**Subject:** Fwd: Further comments on planning application 6/2021/10079/FULL

[REDACTED]  
**Date:** 26.3.2021  
**To:** [planning@welhat.gov.uk](mailto:planning@welhat.gov.uk)  
**Subject: Further comments on planning application  
6/2021/10079/FULL**

Re your letter dated 17th March inviting further comments on the retrospective application.

Project Address	8 Hill Rise, Potters Bar, EN6 4EE
Sheet Title	As Built Site Plan
Sheet Number	A106
Paper Size	A1
Revision	
Issue Date	01/01/2021

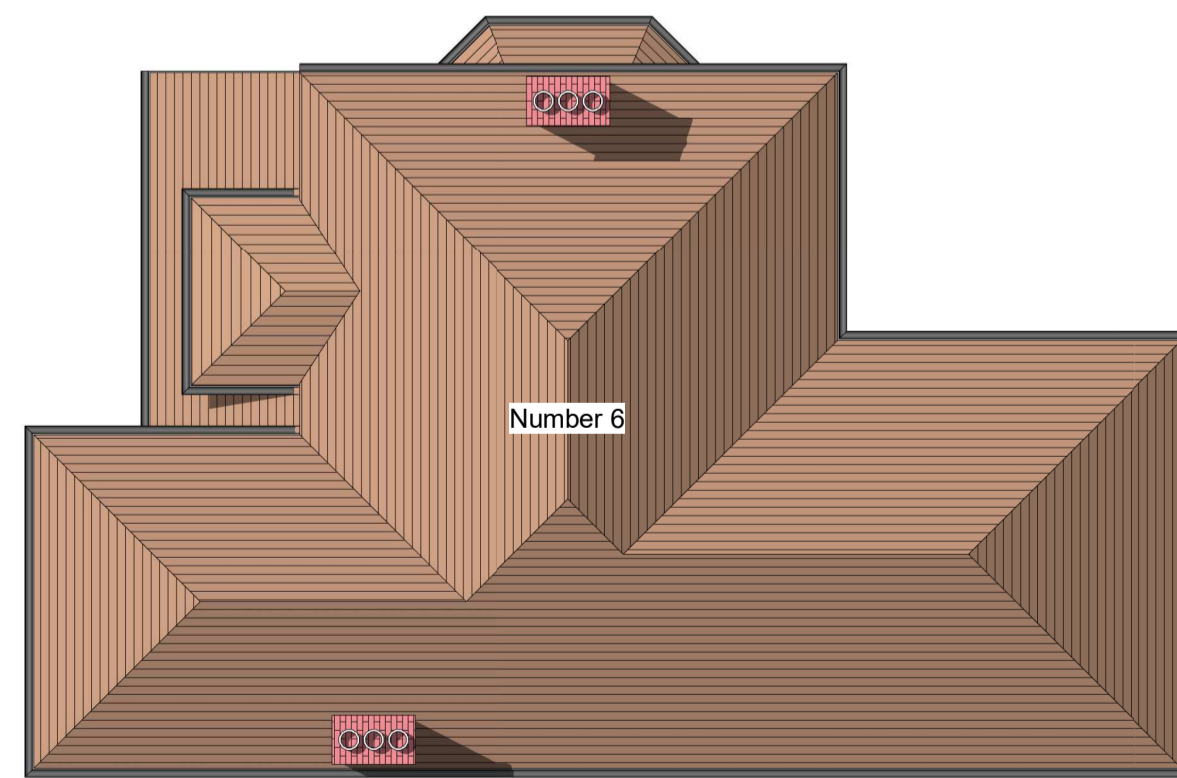
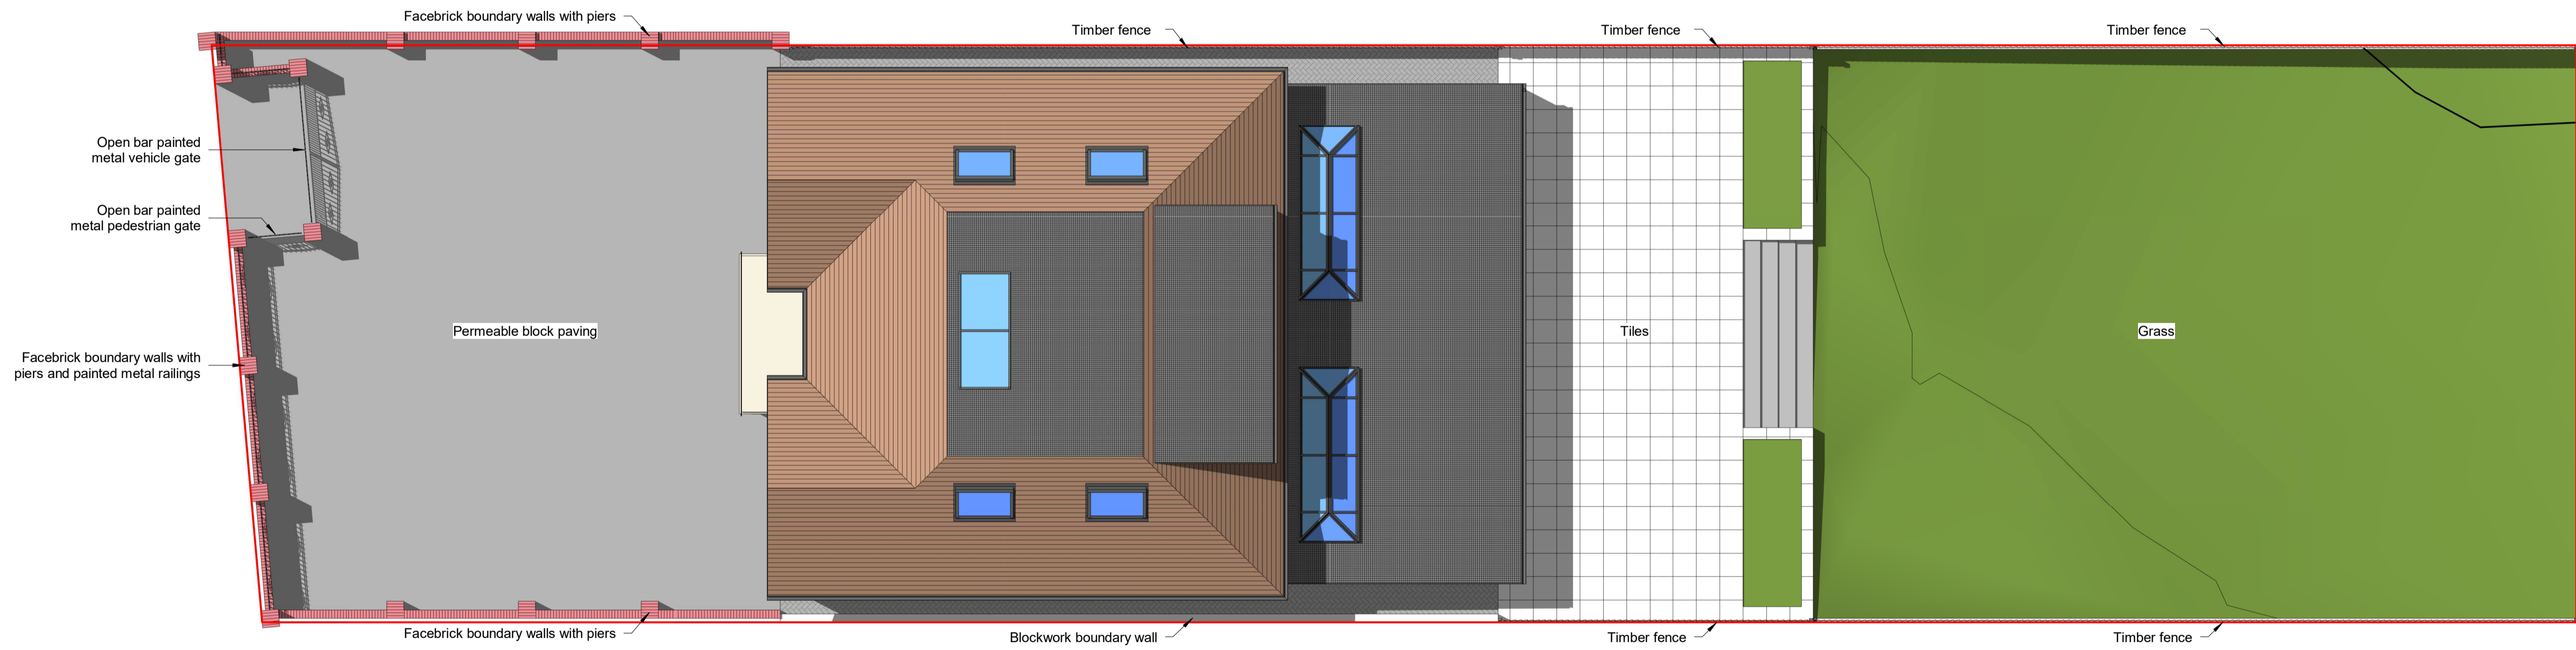
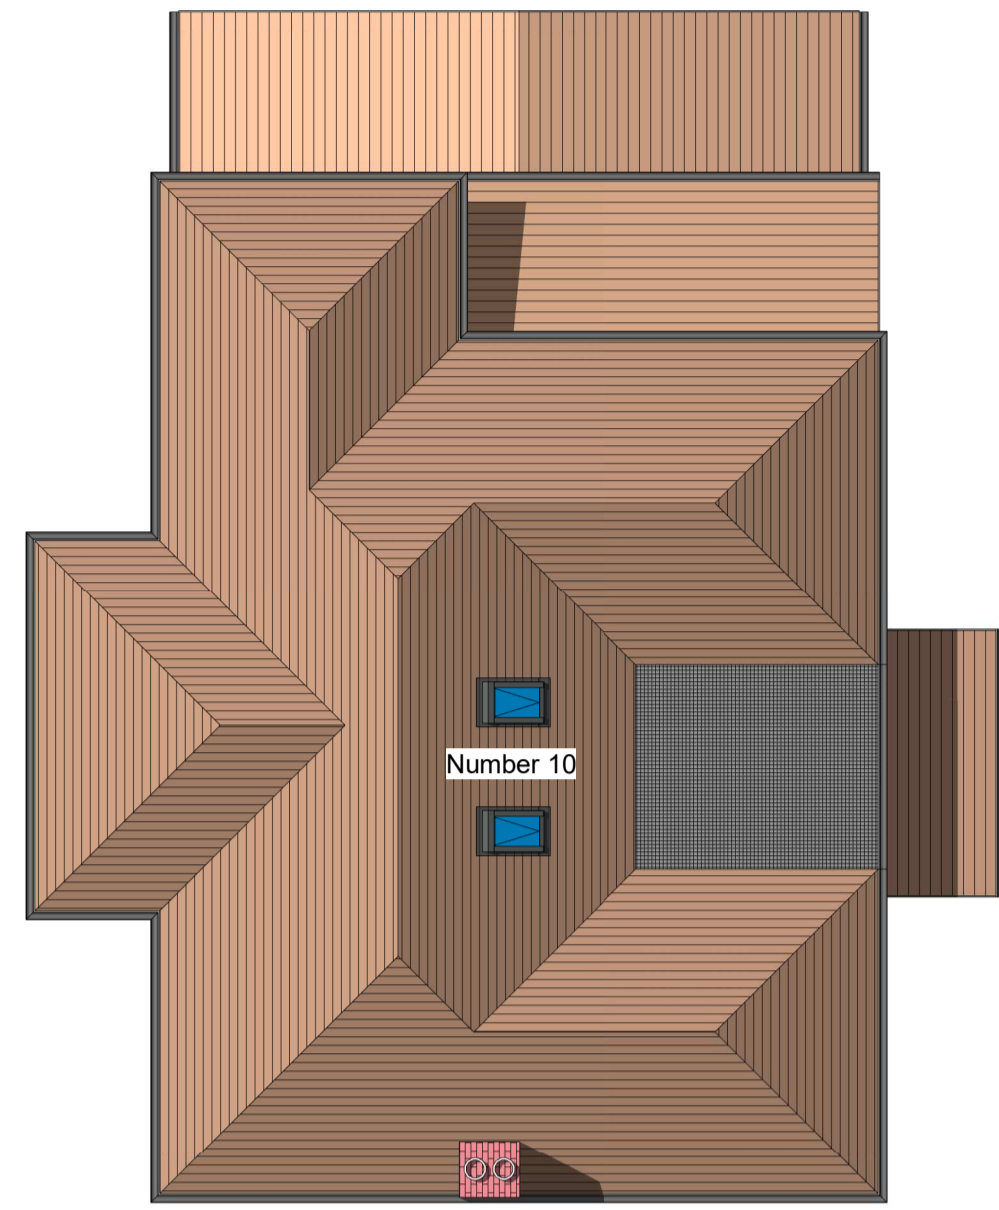
The original plans quoted soft landscaping which has not happened. This is not inline with current thinking and conservation issues.
